**SSD 8636 – SYDNEY UNIVERSITY ENGINEERING AND TECHNOLOGY PRECINCT –
ENVIRONMENTAL IMPACT STATEMENT (EIS)**

SARAH THOMSON
Unit Head, Metropolitan Infrastructure
NSW Environment Protection Authority

SYDNEY UNIVERSITY ENGINEERING AND TECHNOLOGY PRECINCT

1 SHEPHERD ST ELEVATION
A-DA-3005 SCALE 1 : 200

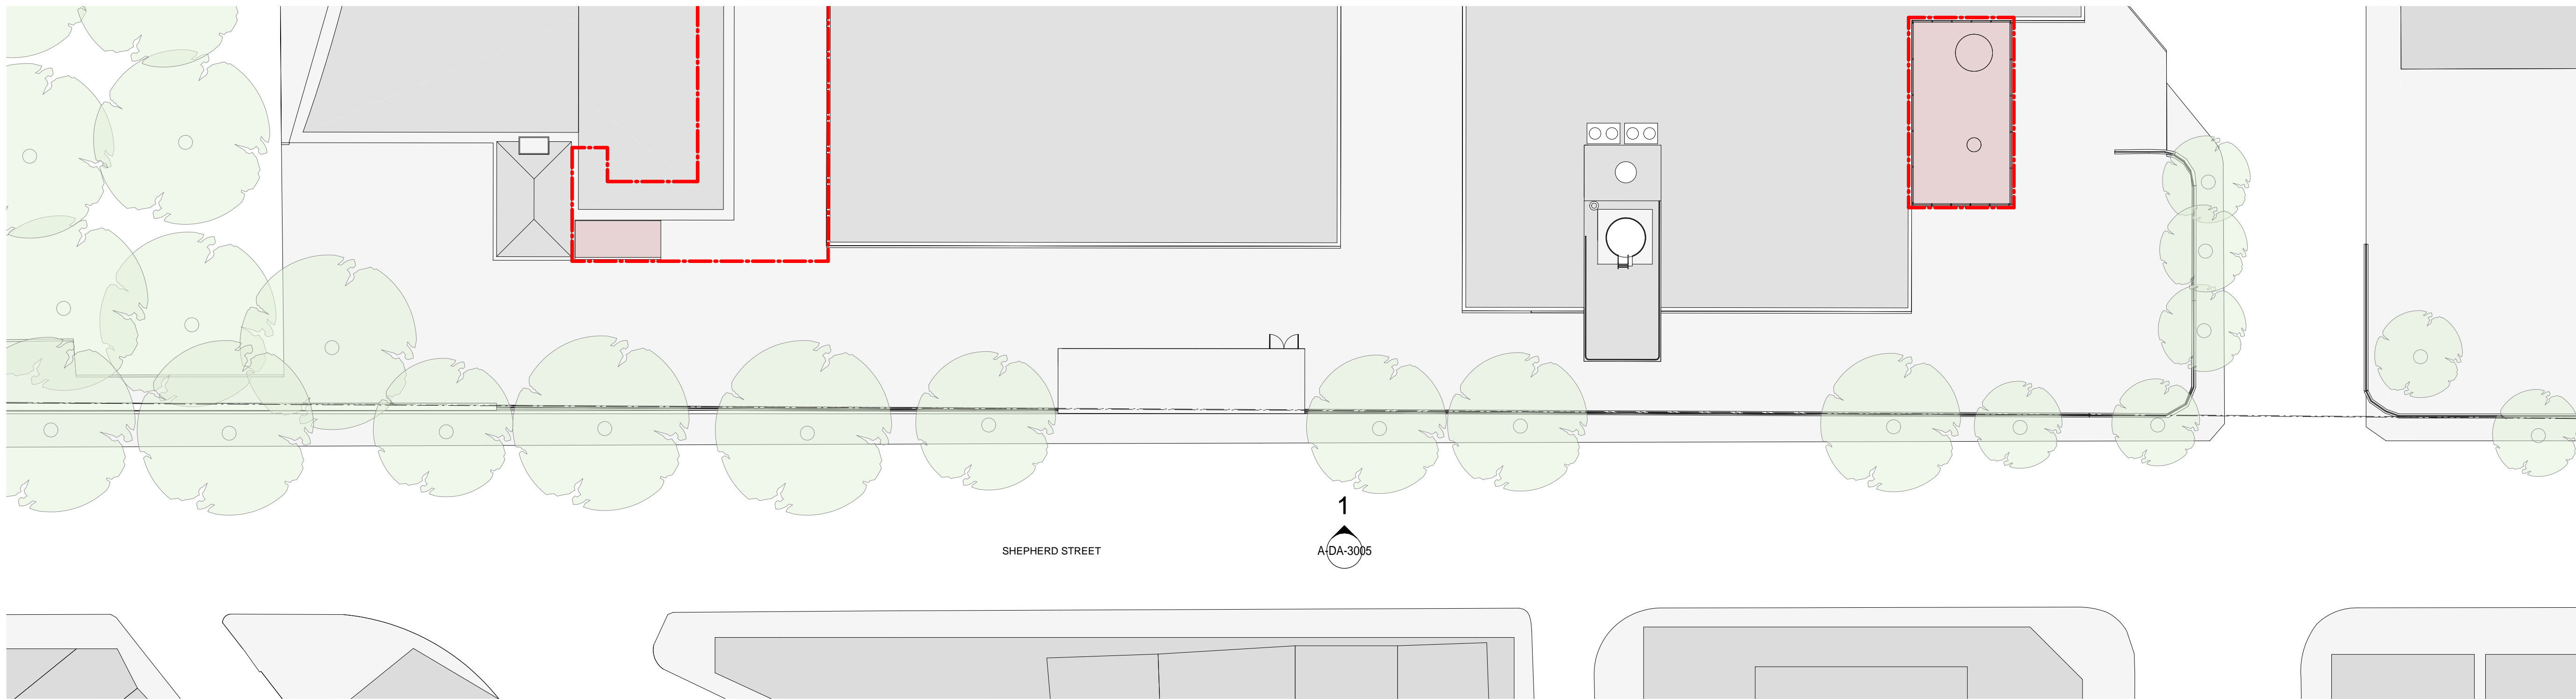
EIS Drawing A-DA-3005 *Shepherd Street Elevation* indicates that the new loading dock entry is proposed opposite residences in Shepherd and Boundary Streets.

The proponent be required ensure delivery vehicle movements are not undertaken outside the hours of 7.30 am to 6.00 pm Monday to Friday.
